2022/0996

Description: Two storey and single storey side extension

Address: Bank Cottage, Thurgoland Bank, Thurgoland, Sheffield, S35 7BR

Proposed Block Plan
Scale 1:500
© Crown Copyright and database rights 2021
OS 100047474

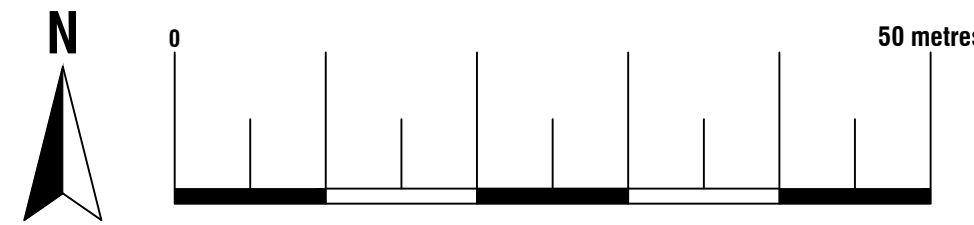
Concern was previously raised that the proposed extension would encroach upon visibility splays from the site onto B6462 Thurgoland. It was requested that a drawing should be provided that demonstrates vehicular visibility splays of 2.4m x 43m which are within the control of the applicant and contain no obstructions over 0.6m.

In receipt of this, it was considered that despite the fact the splay crosses third party land, the access is already used by the property. Highways visited the site and noted it had been re-surfaced and lined and the verge tidied so the eastern side of the access is now a stone-filled drainage channel. The works appear to have improved the visibility available to drivers exiting the site. To the west, there is an historic high wall and mature vegetation that would impinge on visibility more than the proposed extension. It is considered that the visibility splay was acceptable.

Proposed East Elevation
Scale 1:50

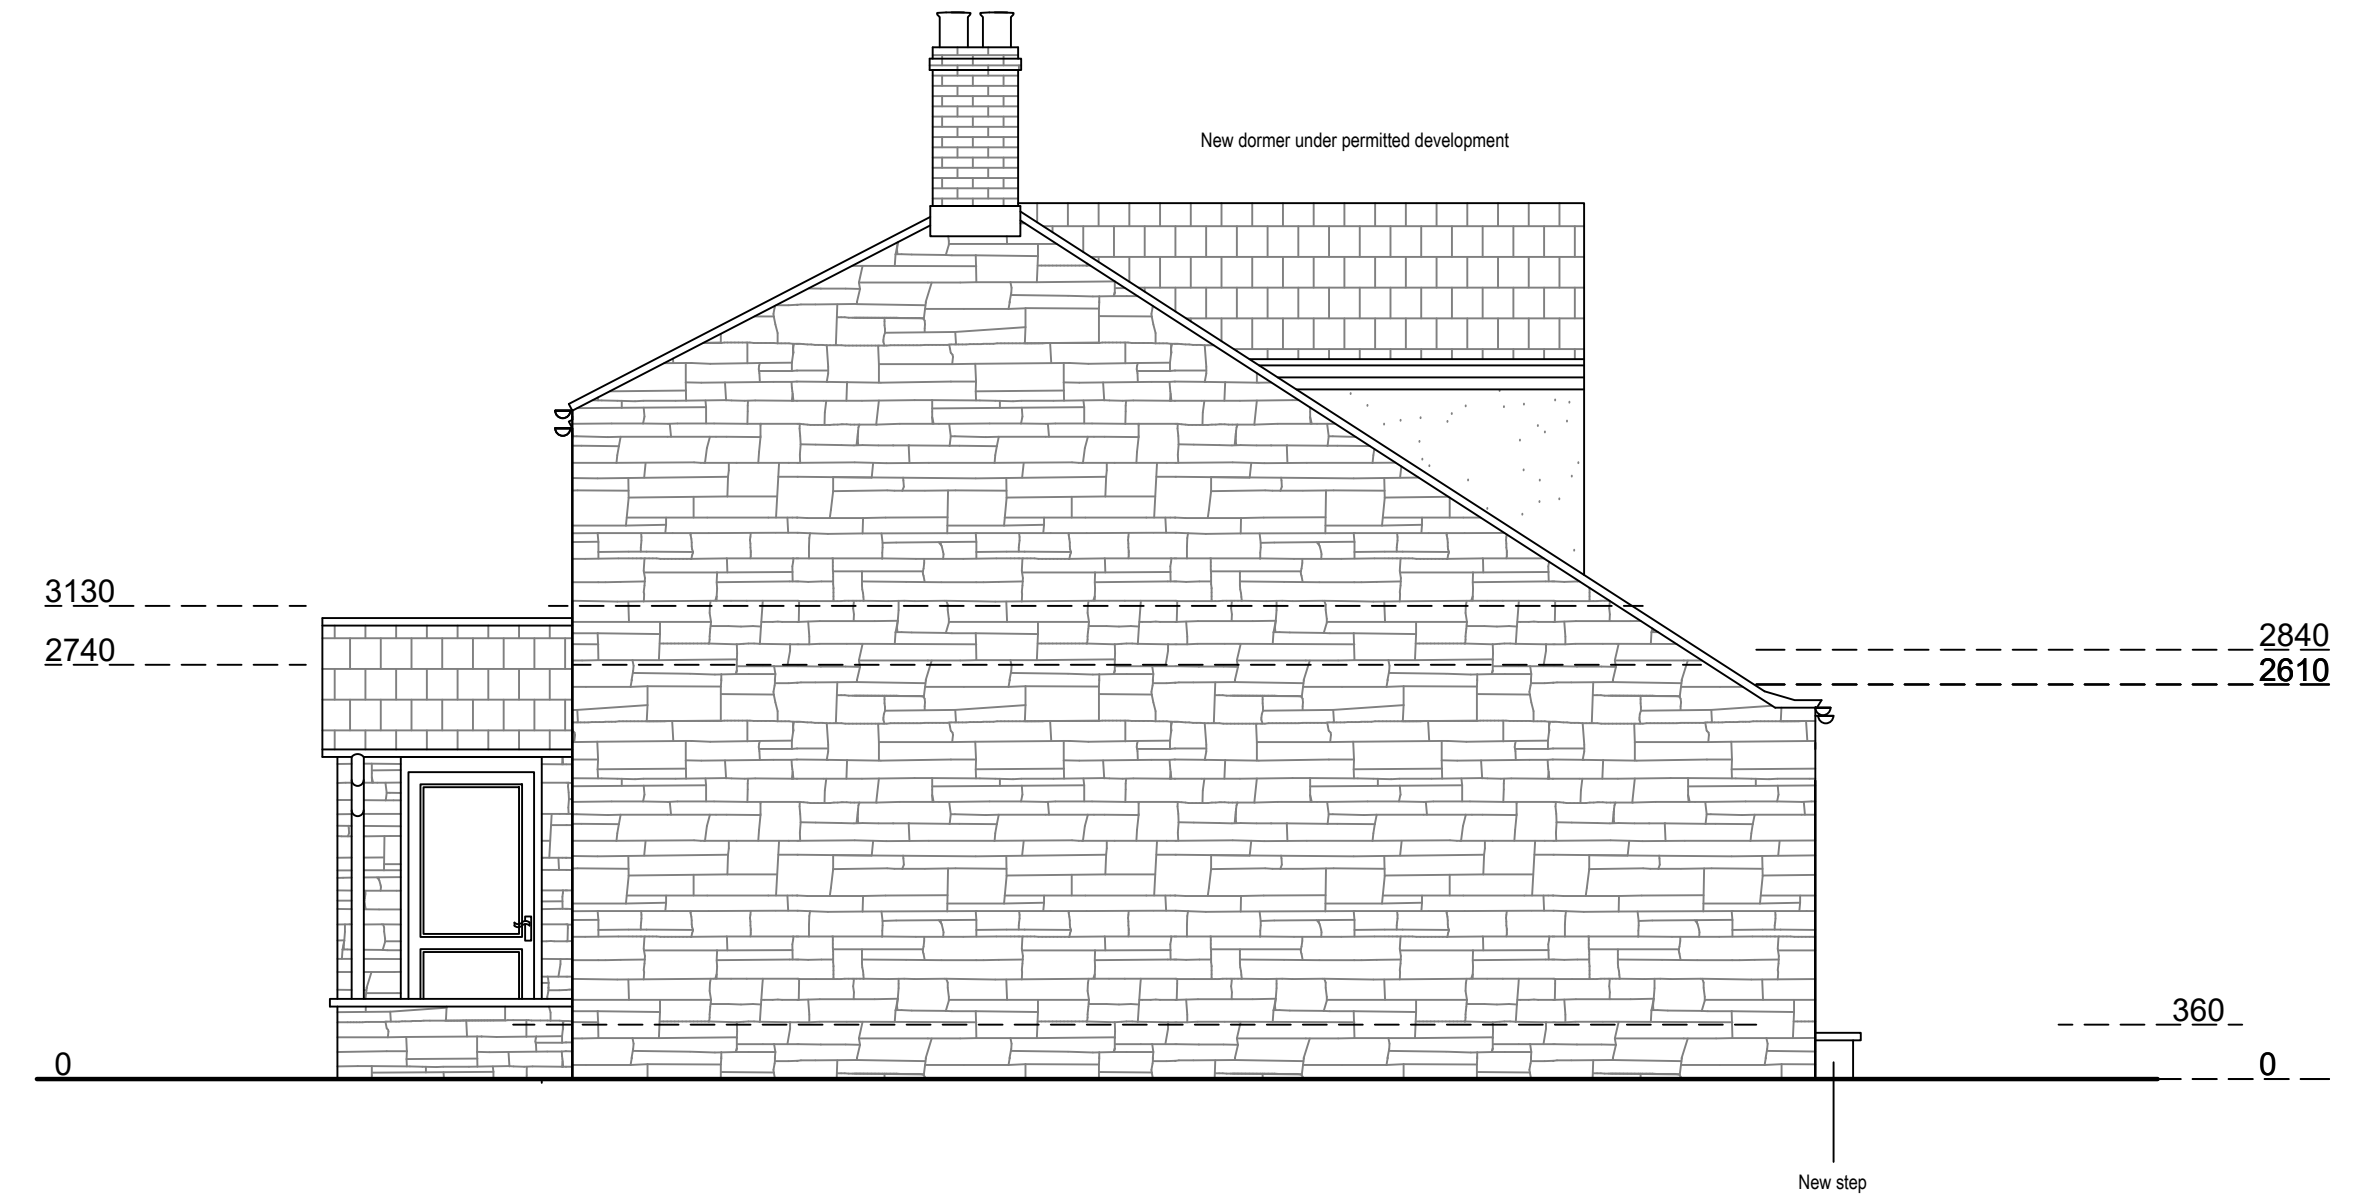
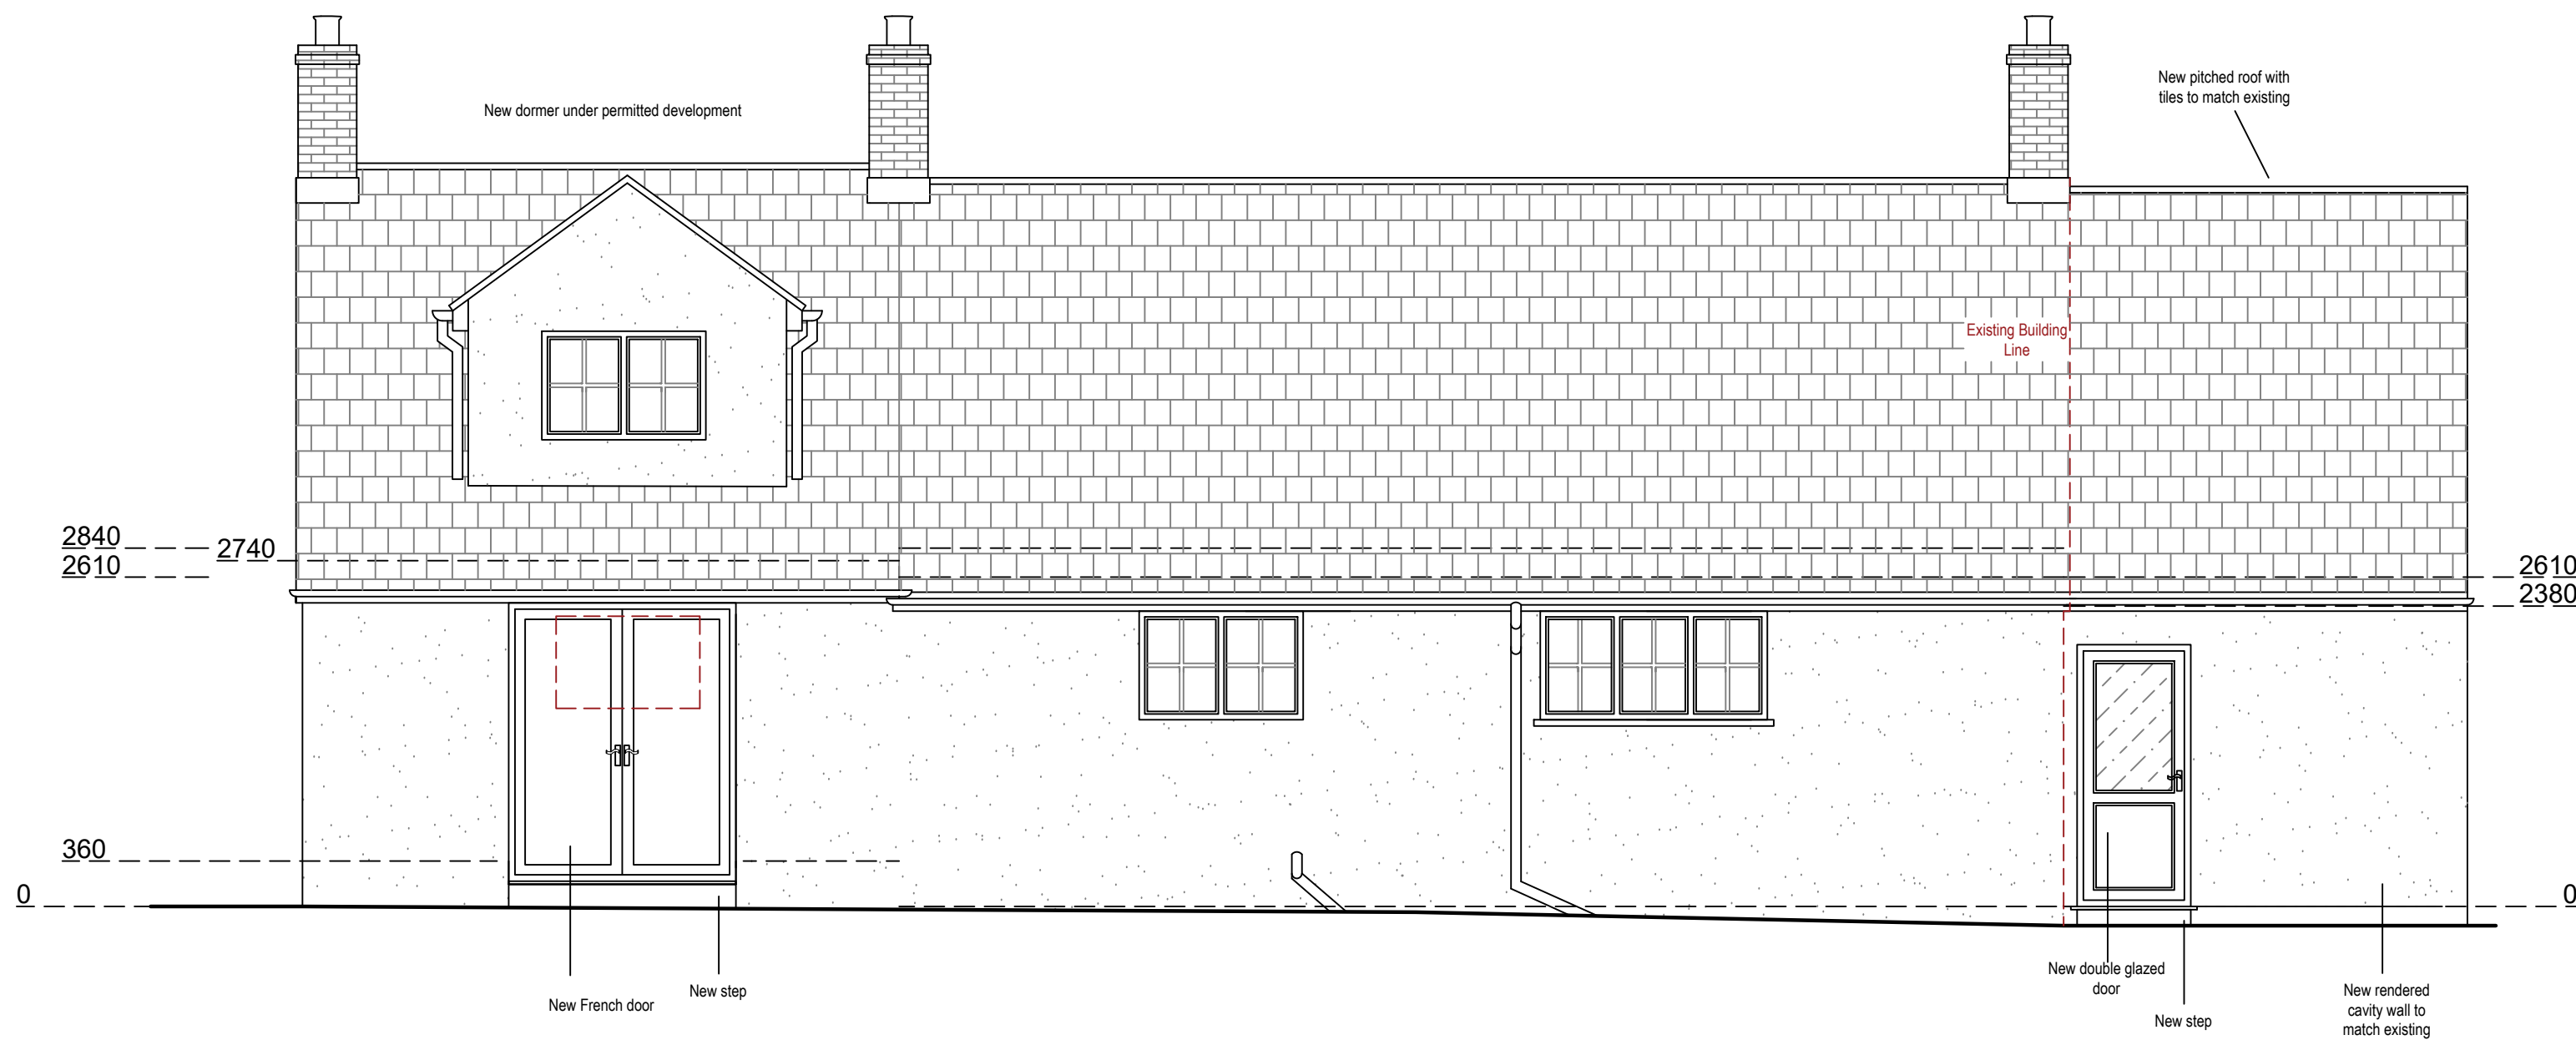
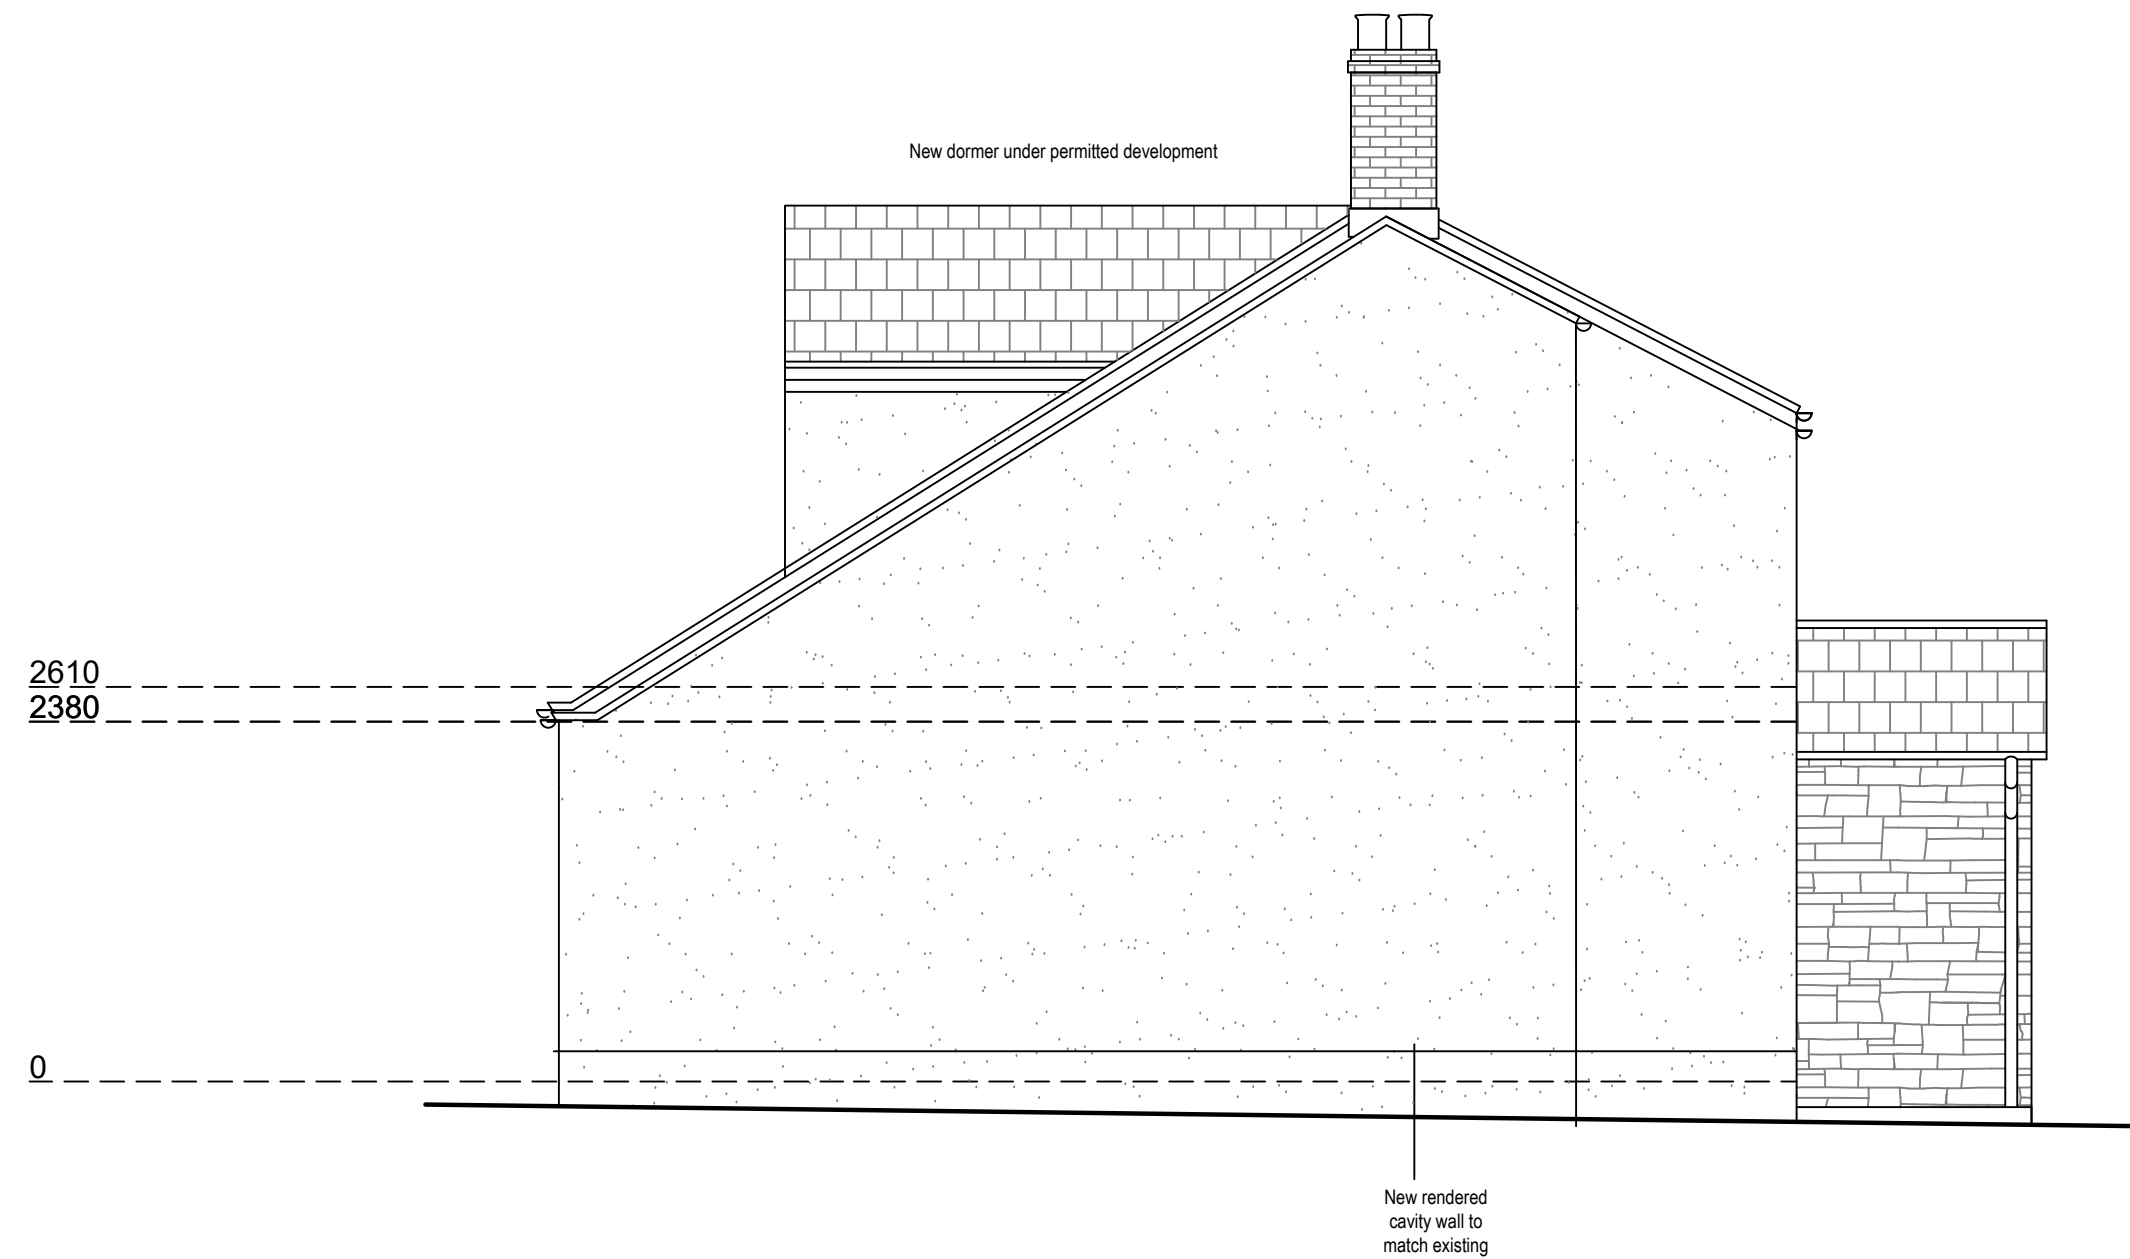
Amended plans were requested throughout this application to ensure a set back and set down was achieved so that the extension would appear subordinate. The extension is set back 1.5m from the principle elevation of the dwelling and set down by 0.21m from the ridge.

This set down and substantial set back, in addition to the fact that there are no properties to the side of the subject dwelling would ensure the extension appears as an extension. The extension would have a dual pitch roof following the form of the existing roof and the sideways projection would not exceed more than two thirds the width of the original dwelling.
